Town & Country Planning Act 1990 (as amended)

Double garage with utility - Resubmission of LU/45/12
8 Mantling Road Littlehampton

Location Plan
Scale 1:1250

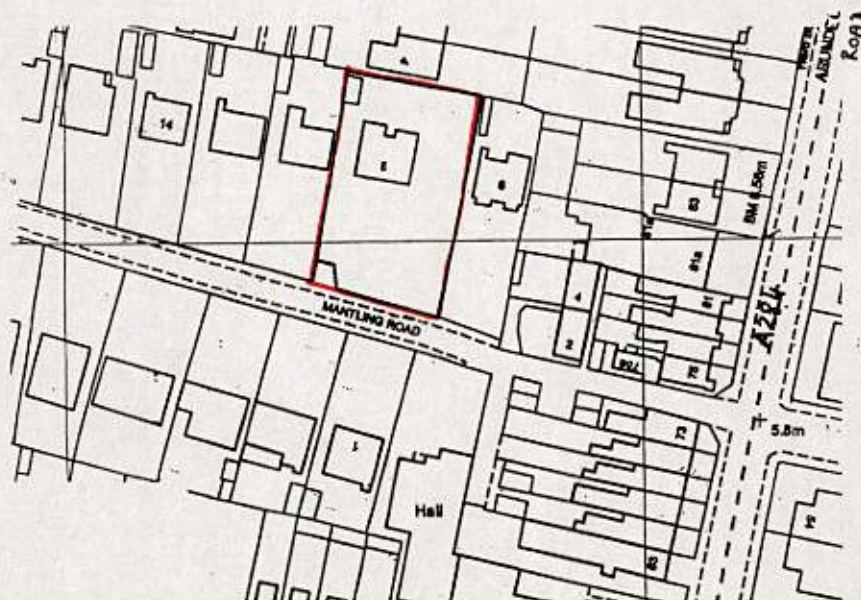
The plan of the current site is not correct. The current plans do not show the existing extension, (LU/386/73/B). This, I would assume, will be demolished? □
